## **Application by Anglian Water Services Limited for an Order Granting Development Consent for the Cambridge Waste Water Treatment Plant Relocation project**

### **The Examining Authority's third written questions and requests for information (ExQ3)**

**Issued on 21 March 2024**

- Scheme Order Limits
- Land ownership data
- Site 3
- Waterbeach corridor
- Contains plot 042a
- Contains plot 038c
- Contains plot 036b and 036c
- Contains plot 046b

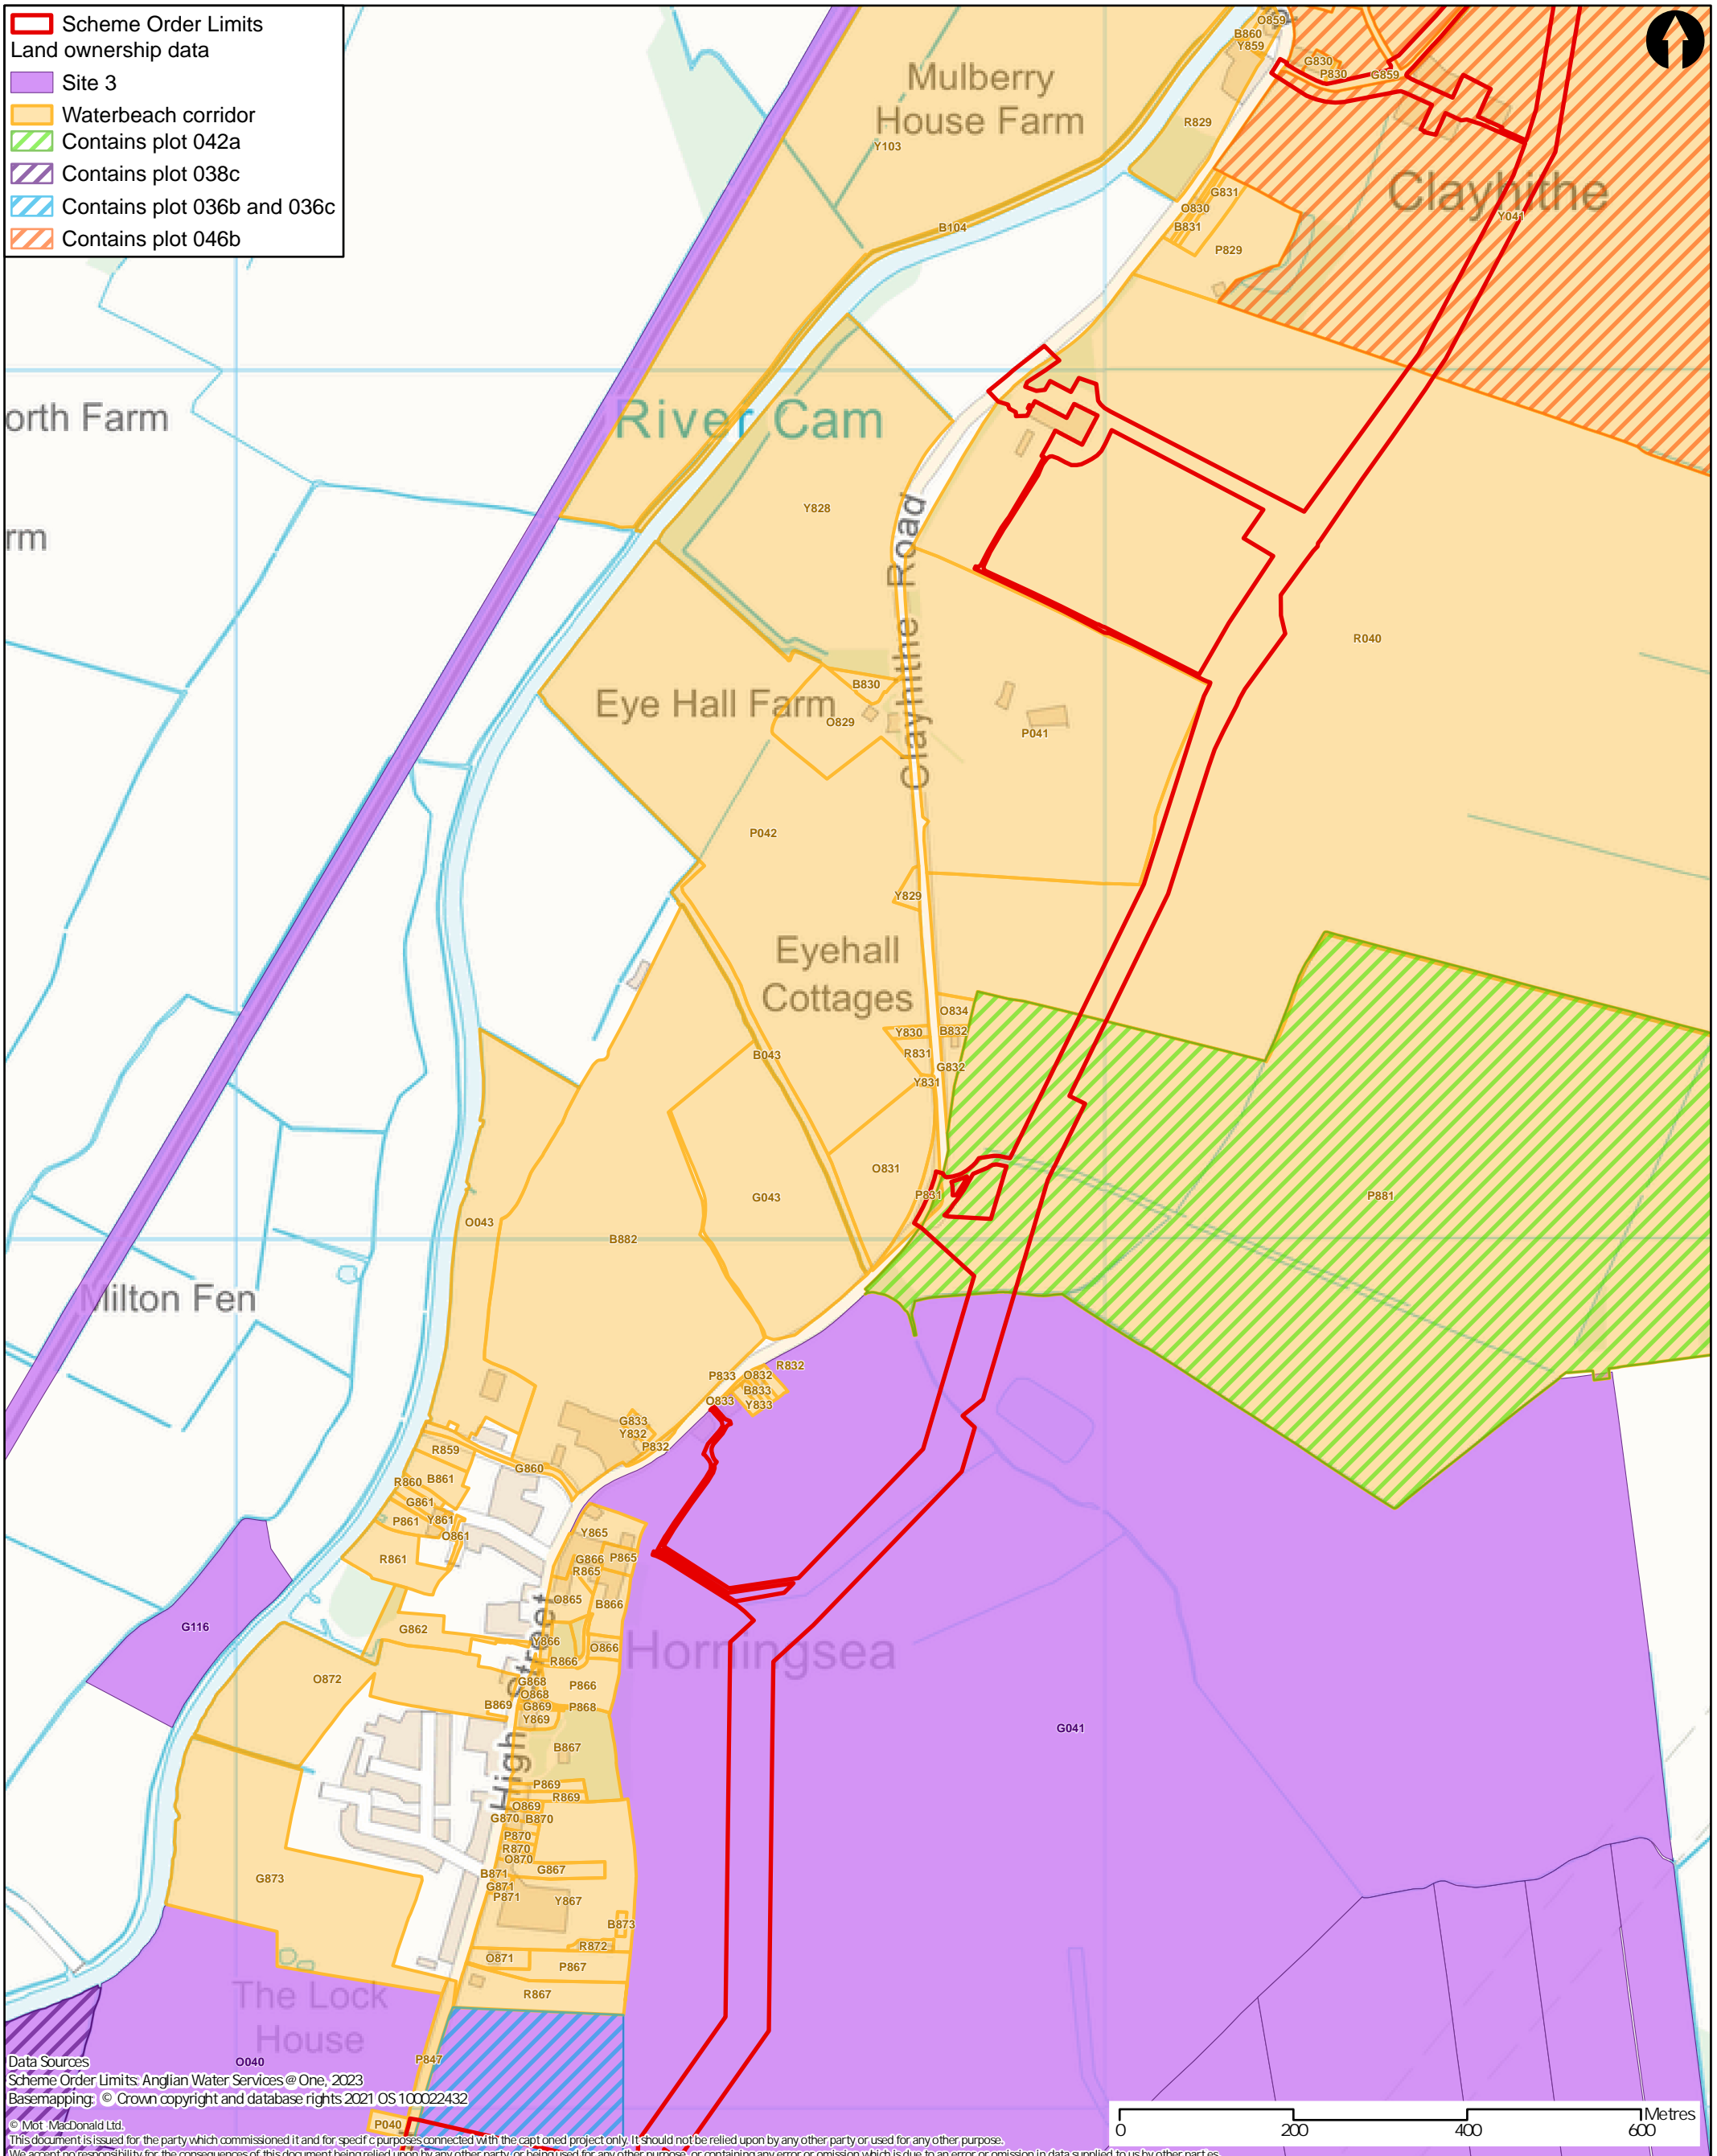
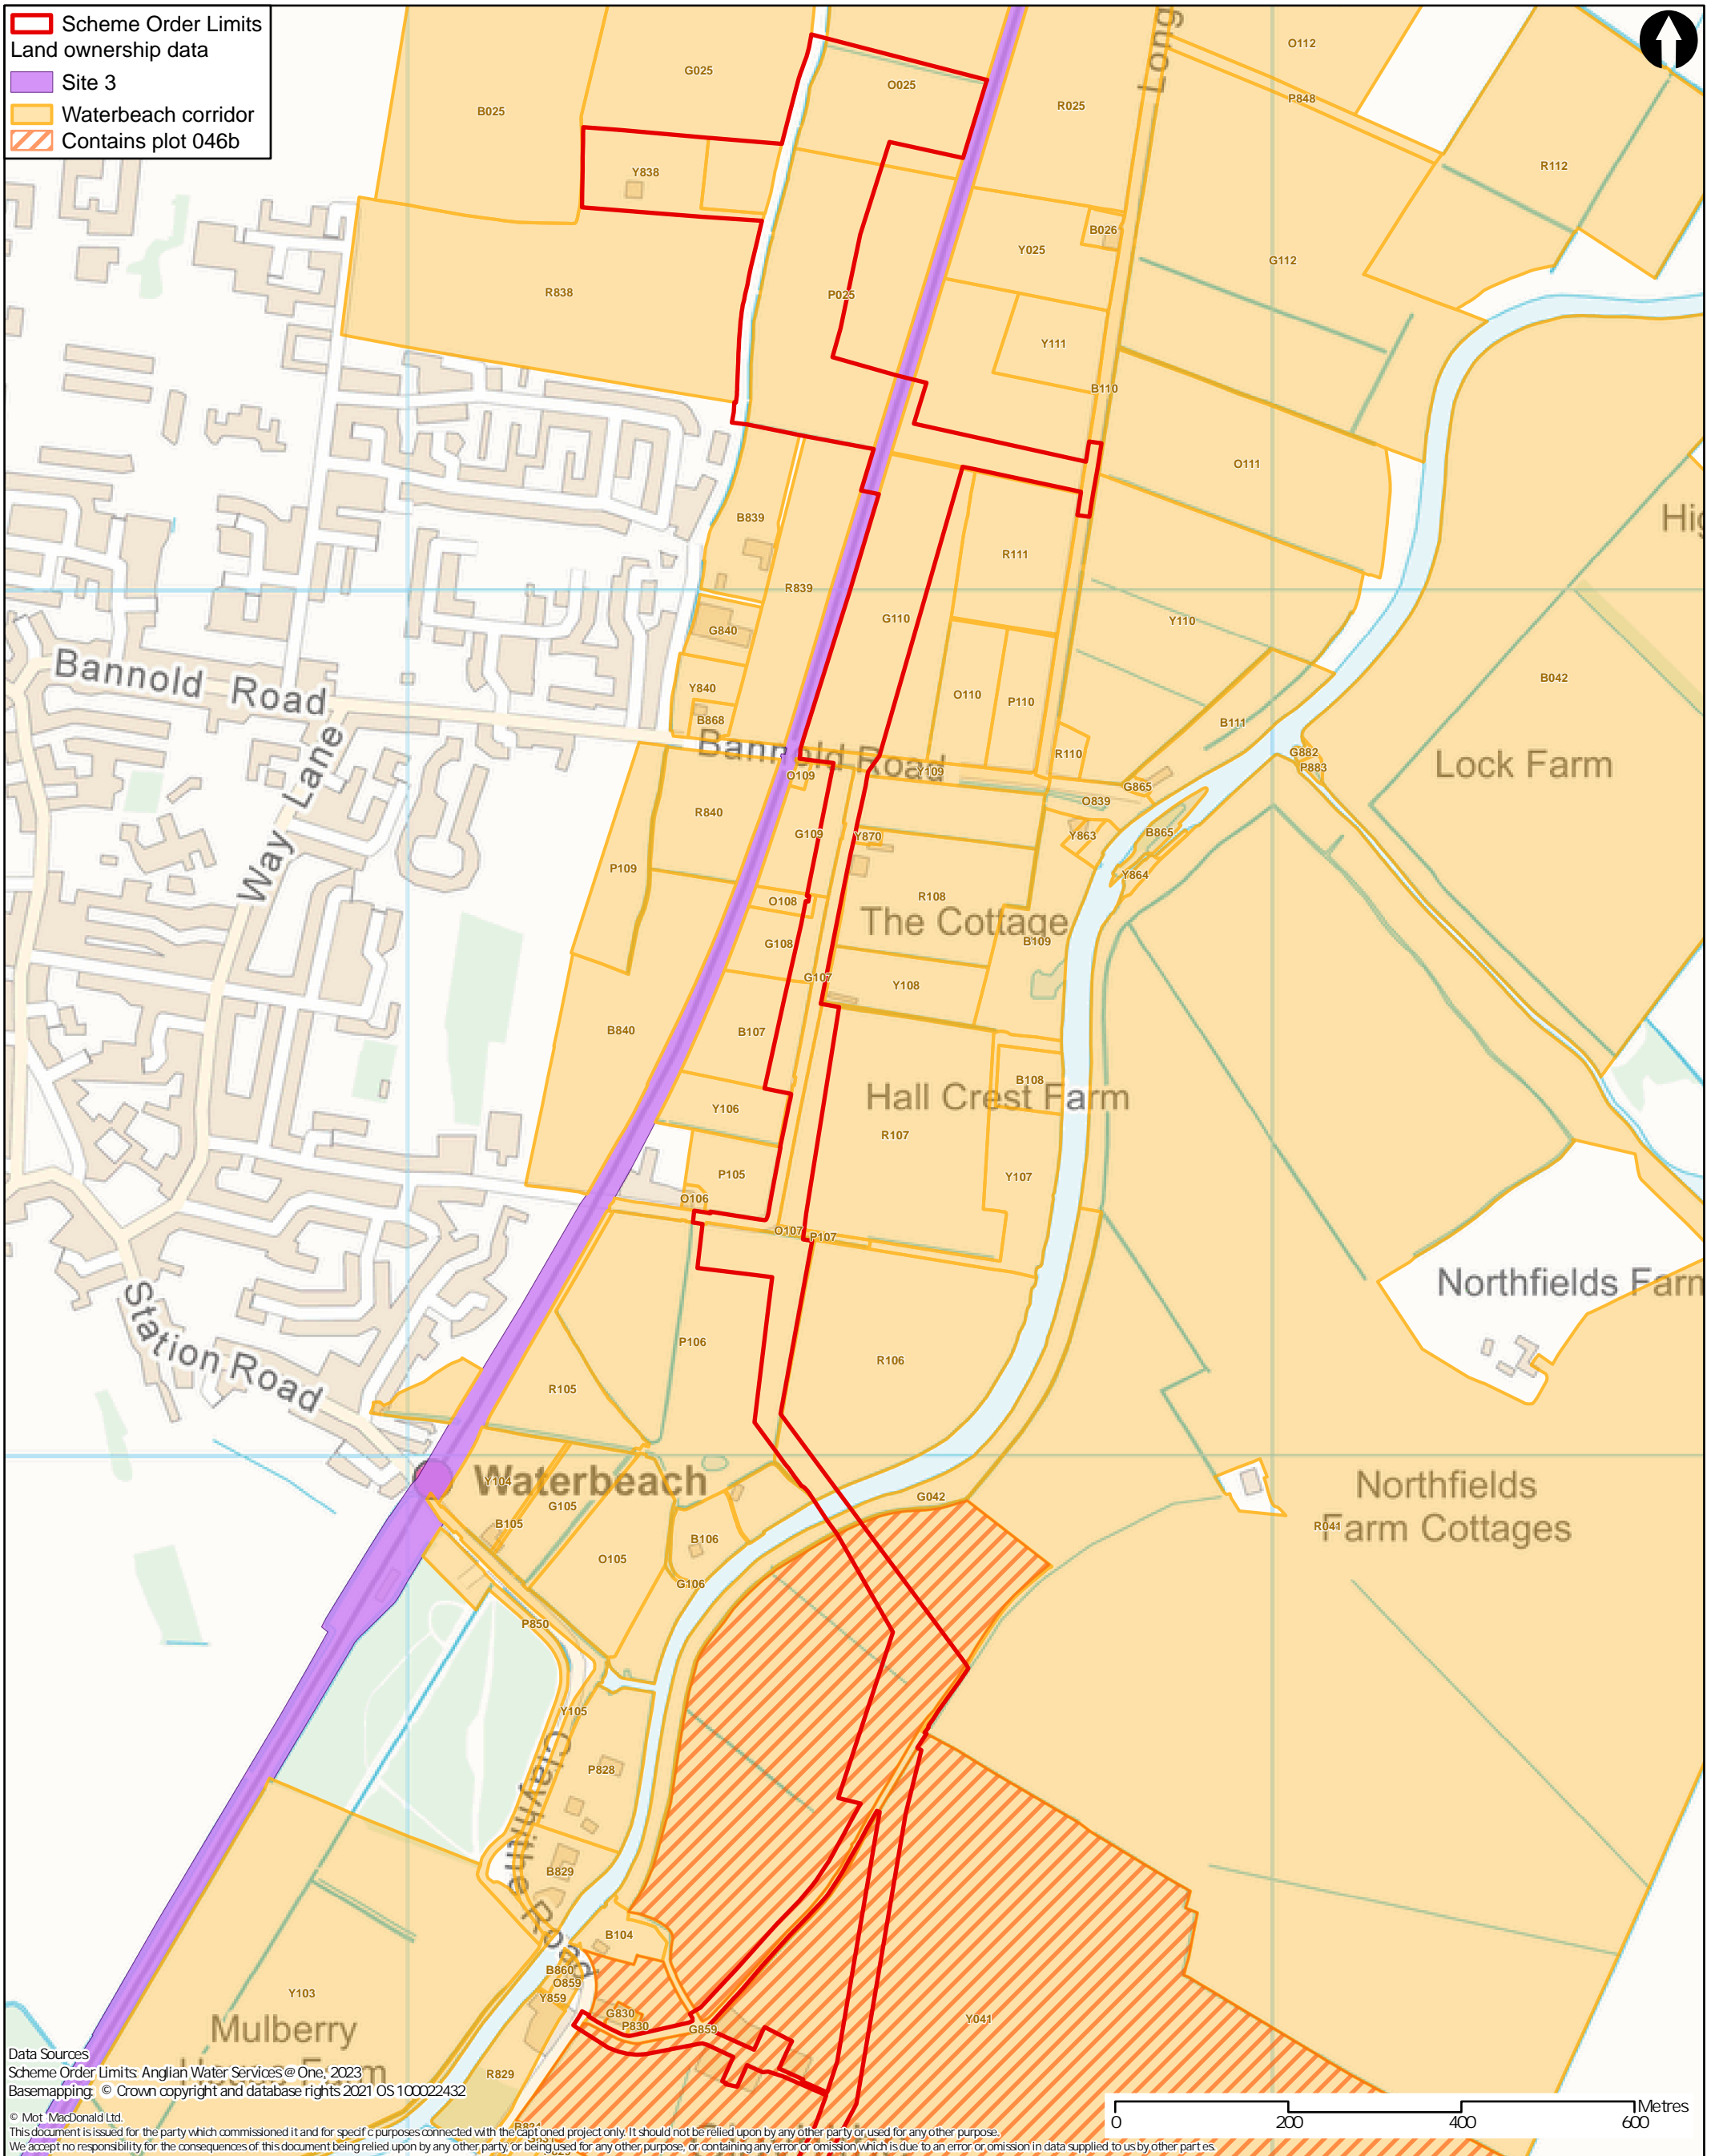
3.1	Applicant	<b>Farm holdings clarification</b> It is unclear from ES Figures 6.11 to 6.14 [AS-049] which farm holdings Plots 036b, 036c, 038c, 042a and 046b relate to. Please clarify / rectify.
<b>4. Air quality</b>		
No further questions at this stage.		
<b>5. Biodiversity</b>
